CITY OF ALBUQUERQUE

Re: AIK VOLLEYBALL COURT
5110 Copper Ave NE
Traffic Circulation Layout
Engineer's/Architect's Stamp **04-15-19** (K17D118)

Based upon the information provided in your submittal received 04-24-19, the above referenced plan cannot be approved for Building Permit until the following comments are addressed:

TRAFFIC CIRCULATION LAYOUT PLAN

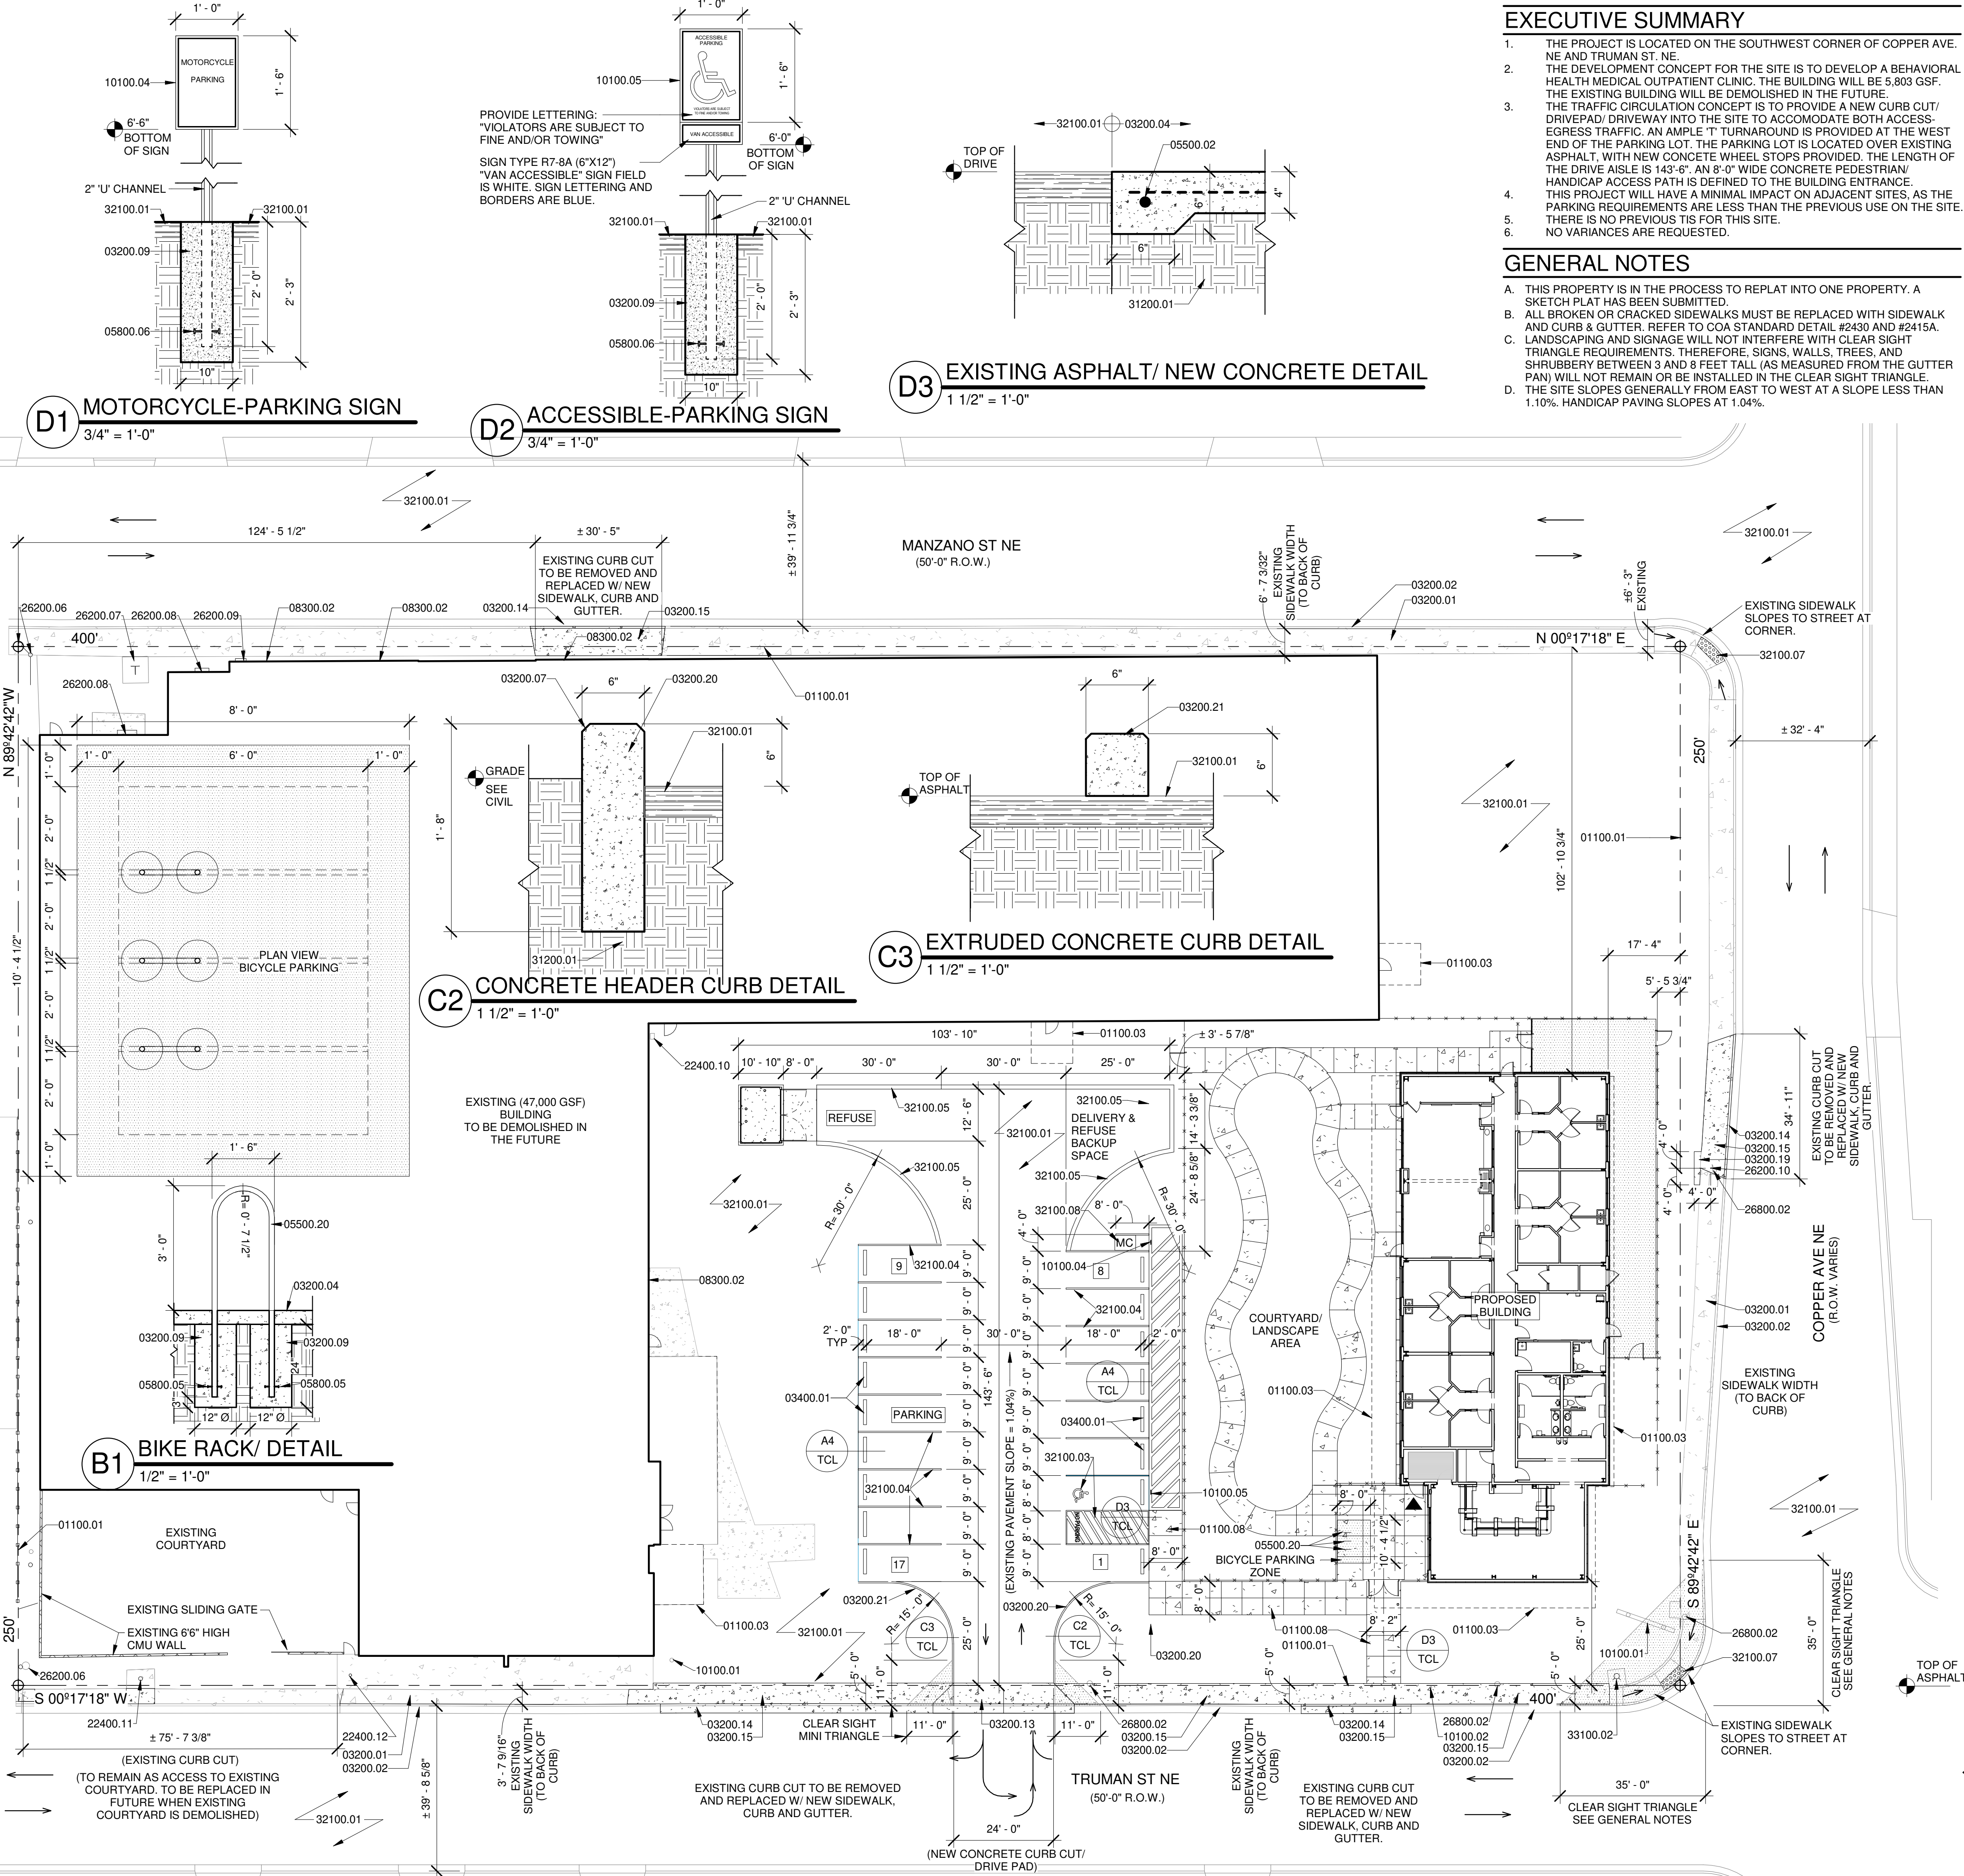
1. Unused curb cuts must be replaced with sidewalk and curb & gutter. A build note must be provided referring to the appropriate City Standard drawing.

2. Add a note stating "All broken or cracked sidewalk must be replaced with sidewalk and curb & gutter." A build note must be provided referring to the appropriate City Standard drawing.
3. When the transportation department visited the site, it was noted that none of the ADA ramps were built according to standards. Please take care of that.
4. The existing drive pad located on the south side of the Truman St. needs to be smaller. Consider changing the width to 25'.
5. The 66' drive pad is very wide and the way it's been set up now interferes with ADA parking spaces. Please shrink it to 25' in a way that the ADA spaces are not in front of the entrance.
6. Please include **one** copy of the traffic circulation layout at the next submittal.

7. The following detail doesn't match the plan:

Resubmit a revised plan along with fully completed Drainage Transportation Information Sheet to front counter personnel for log in and evaluation by Transportation. PDF copies of the plans and submittal package must be emailed to PLNDRS@cabq.gov at time of resubmittal. If you have any questions, please contact me at 924-3675.
